TECHNICAL NOTE

PROJECT	:	Land adjacent Sefter School House, Sefter Road, Pagham
NOTE REF.	:	Acl673/21023/TN
NOTE TITLE	:	Additional Information requested by the LLFA
AUTHOR	:	Tafari Lewis
APPROVED	:	Tafari Lewis
DATE	:	11 th August 2022

This file note has been produced to provide additional information to Arun District Council (ADC) as lead local flood authority (LLFA) on drainage and flood risk for the proposed development of land adjacent Sefter School House, Sefter Road in Pagham.

Typical Section Through Light Duty Permeable Block Paving Showing

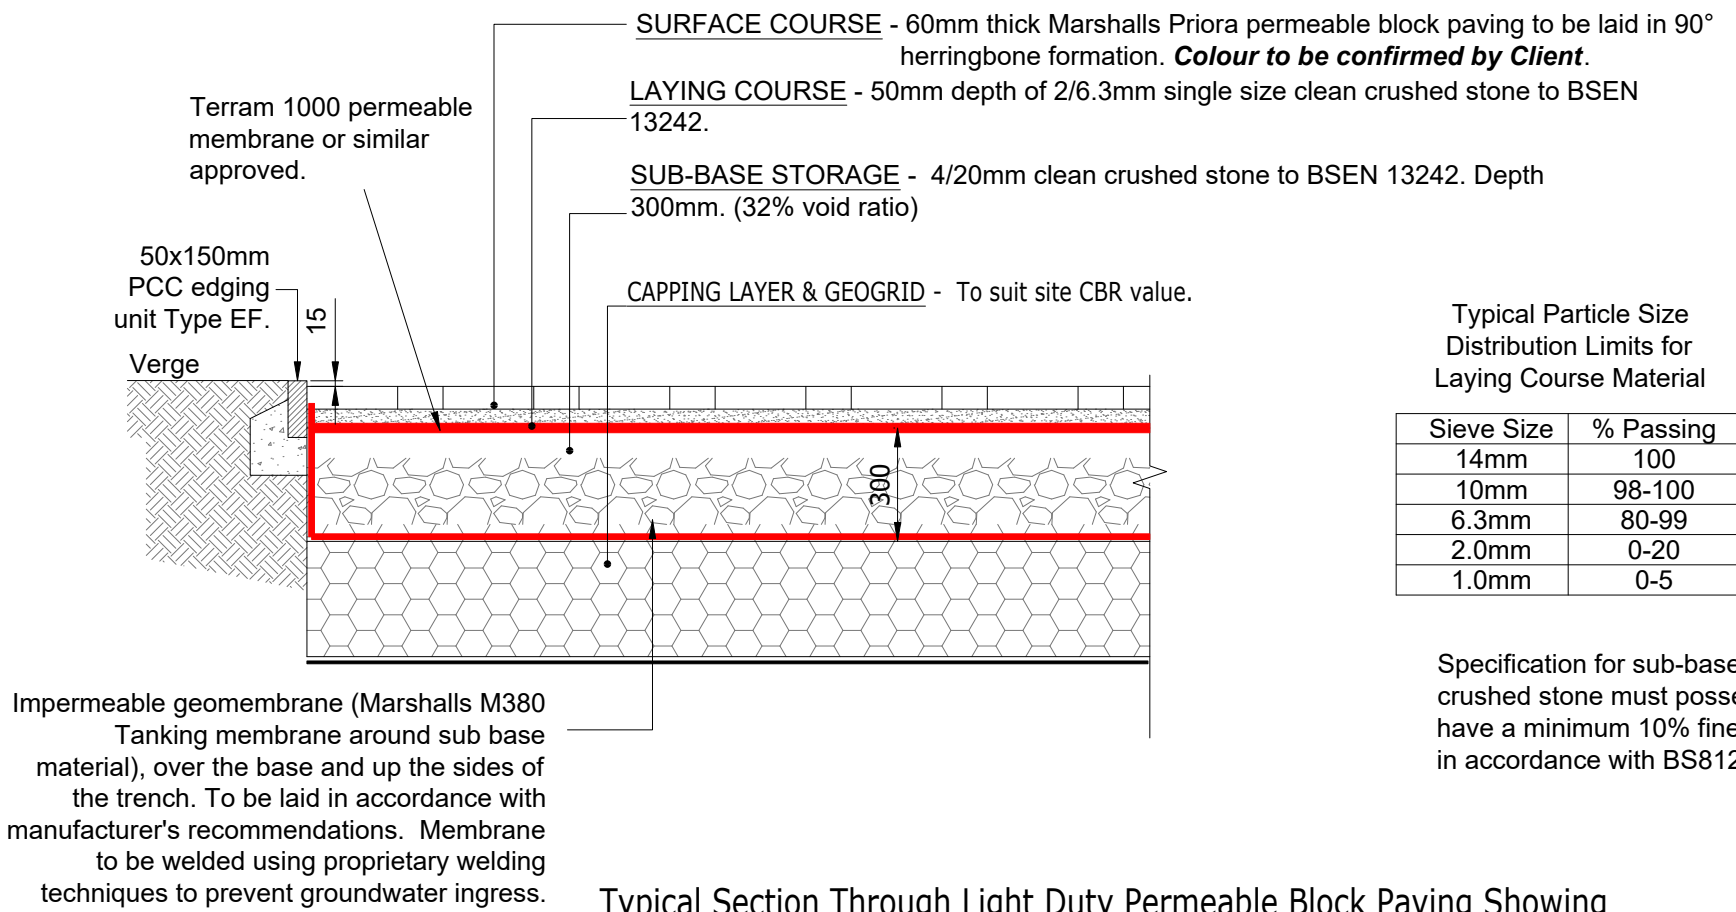
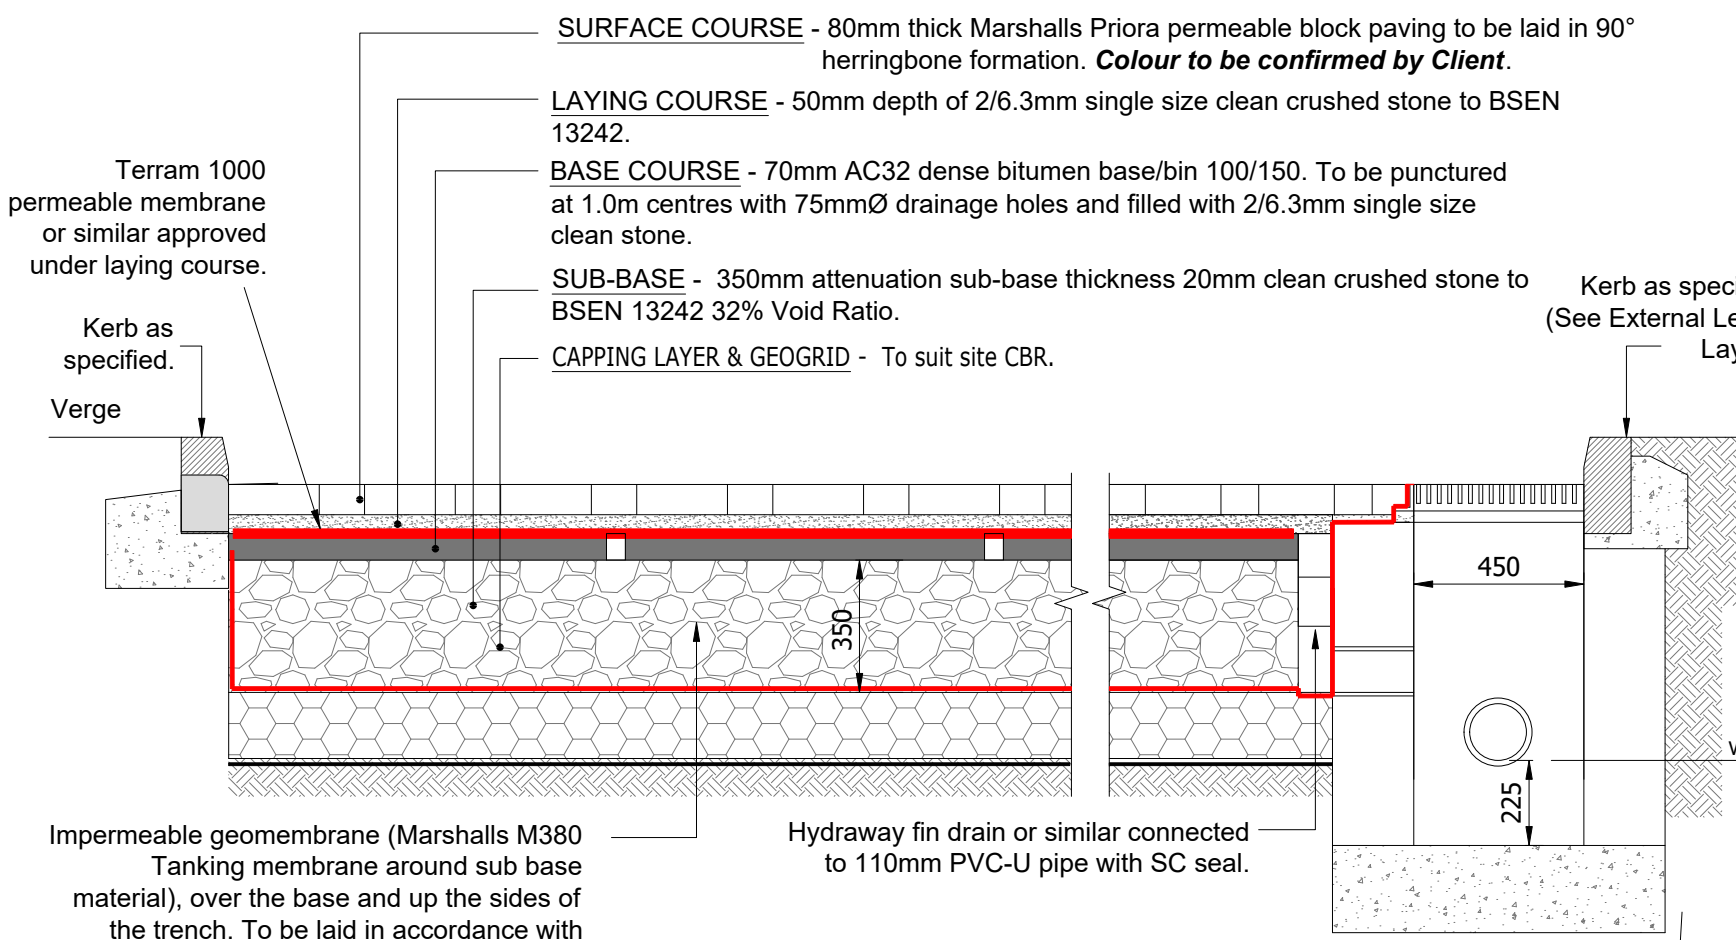
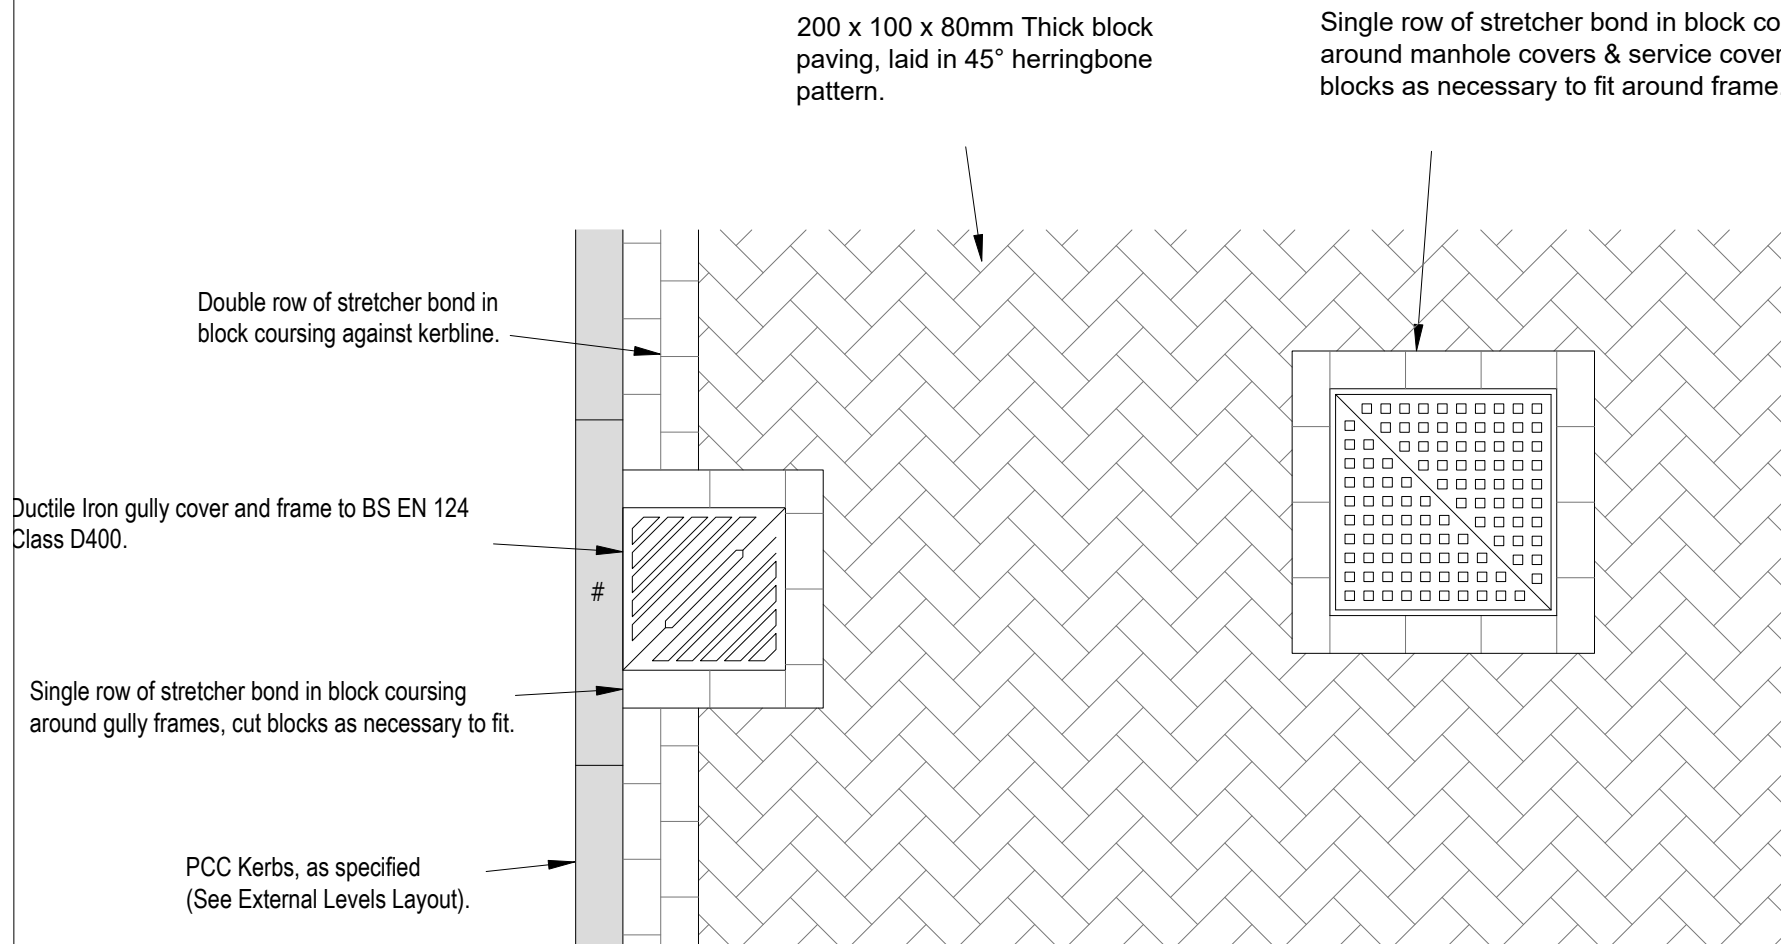
“A 1:80 gradient has been applied to the permeable paving sub-base within the drainage calculations. Nonetheless, the slope across the paving appears to be steeper than this value. The applicant should provide justification for why a 1:80 gradient has been selected within the calculations, to ensure that any differences between the calculations and design levels will not impact on the hydraulic performance of the permeable paving system.”

“The type of membrane surrounding the permeable paving sub-base / specification should be specified on the drawings.”.

The 1:80 gradient represents the vertical alignment of the access which has been reflected within the design calculations. The slope across the paving takes into account existing topography. Noting the LLFA concerns the formation design levels of the paving system have been adjusted on the drainage layout annexed within **Appendix B** to ensure that the hydraulic performance of the system is not compromised.

Marshalls M380 tanking membrane has been specified. Pavement details are included within Appendix B.

ATTENUATION POND
To be co-ordinated with landscaping proposals.
0.85m attenuation depth with 1:3 entry slopes to main pool.
Pool area: 13.7m²
Pool depth: 0.5m
Permanent Water Level: 3.55m
Top of Bank: 4.40m
Peak 1 in 100 year WL + CC: 4.40m
Peak 100 year volume: 41.87m³

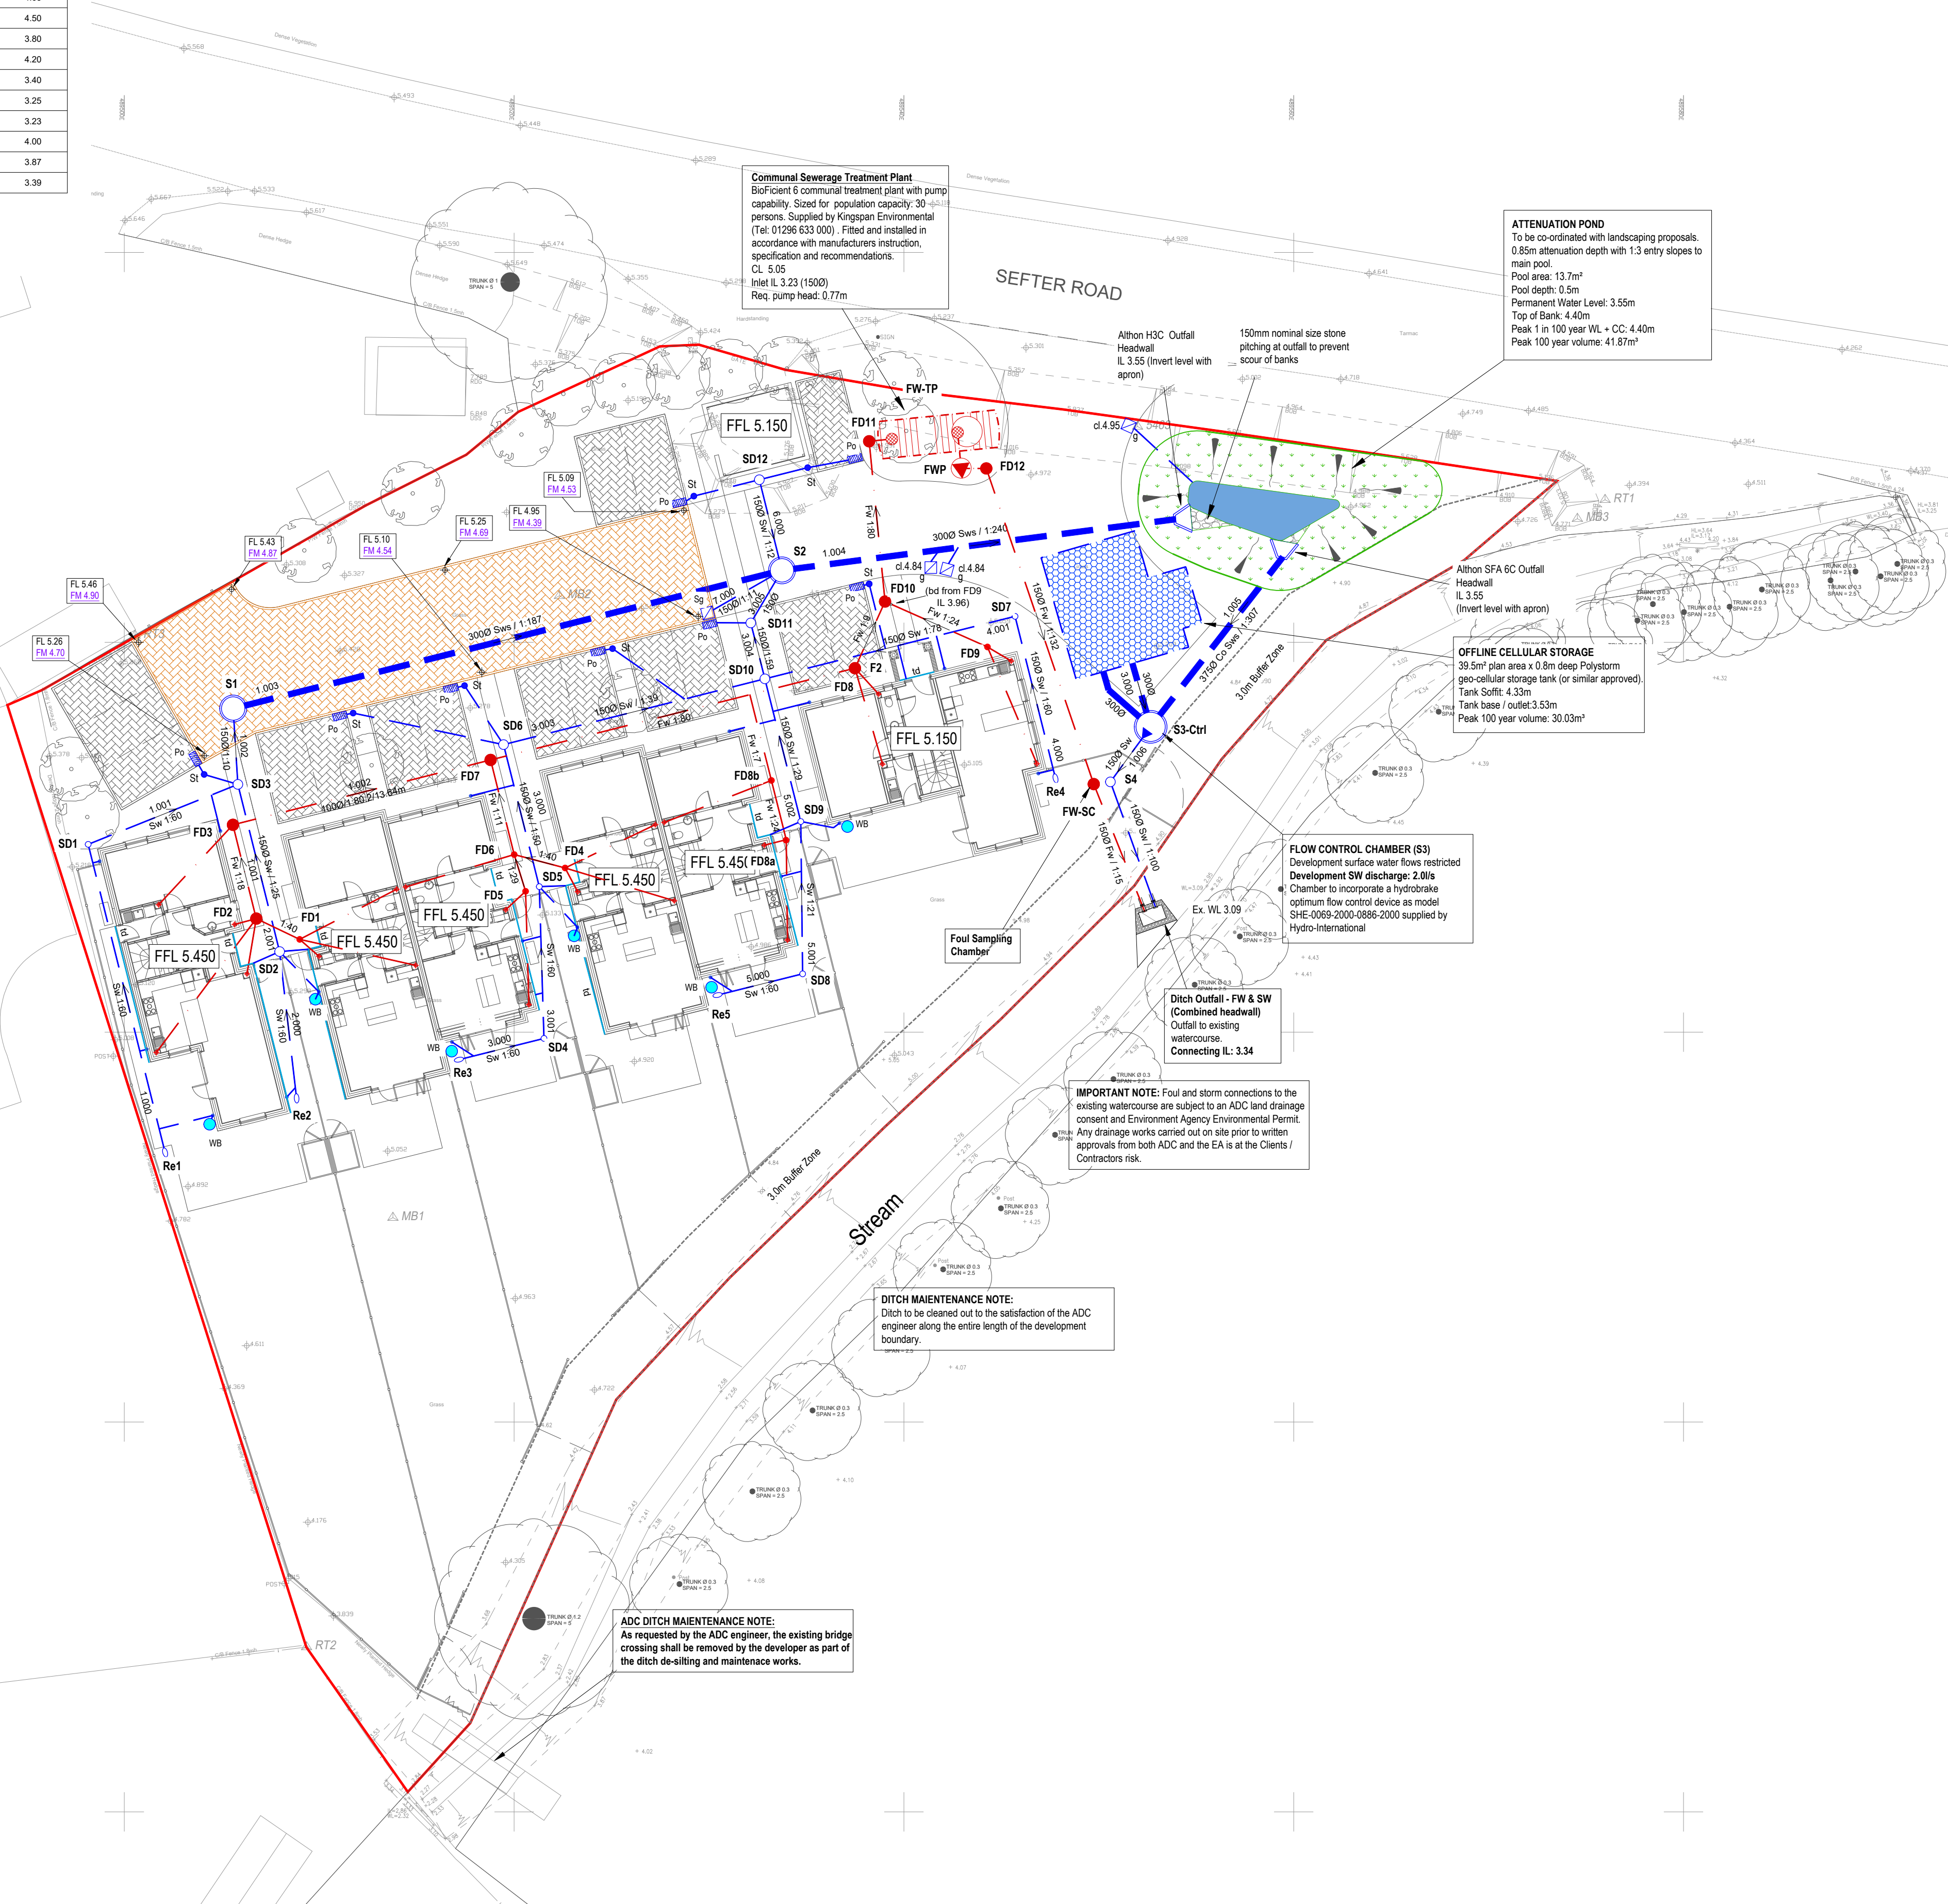
"The design of the pond / basin should include a freeboard of at least 150mm, preferably 300mm or more (in accordance with C753)."

“The pond has a note which states; “To be coordinated with landscaping proposals.” This should confirm that the only details that still need co-ordinating are the planting scheme, as other details leave the pond open to partial redesign, e.g. if landscaping takes precedence over drainage - shallower side slopes or smaller forbay”.

“All inlets into the pond must have headwalls. The inlet pipe from gully to the north west of the pond needs an outfall headwall on the drainage layout plan”.

Noted. The top of bank levels has been adjusted to 4.70m to allow a minimum freeboard of 150mm within the hydraulic calculations. The actual top of bank due to the required earthworks for construction purposes will be in the region of 4.8m to 4.9m as illustrated on the external levels layout drawing in **Appendix B**.

Acknowledged. Note omitted and updated to say wetland planting (species and type) to be confirmed by landscape architects.

Acknowledged. We have now shown an Althon inlet swale headwall for the gully connection and included details for the same in Appendix B.

PROPOSED POLYSTORM STRUCTURE	
Plan Area	39.5m ²
Tank Volume	31.6m ³
Storage	30.02m ³
Polystorm-R Units	79 (PSM1A)
Polystorm-Deep Units	79 (PSM5)

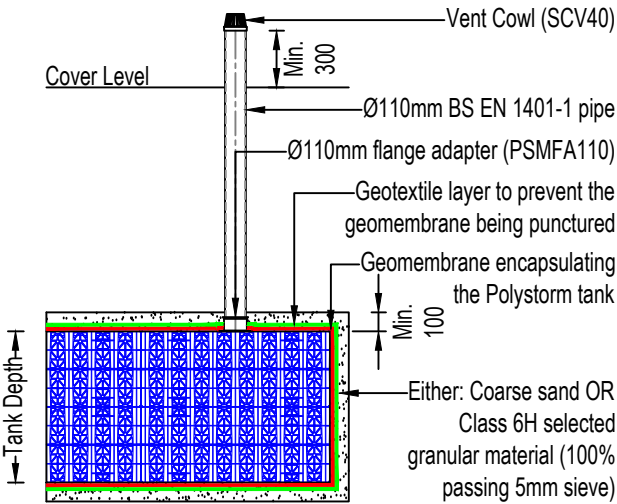
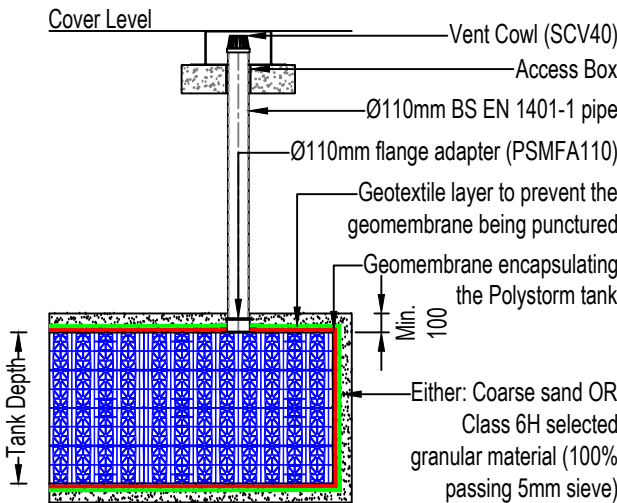
"Regarding the geo-cellular storage, there is a note on both the drainage layout plan and section detail of the storage tank which states "Polypipe Civils (or similar approved)". At DOC stage we require certainty that specifications will be followed, as any changes to the specification may impact associated calculations. As there is no mechanism for enforcing further review of such changes, which could result in significant changes to the design if different crates are approved, please can the applicant remove the "or similar approved" section of this comment from the drawings."

Noted. Reference to similar approved products has been omitted from the drainage layout and section details. Full manufacturer details for the scheme have been included within the drawing updates in **Appendix B**.
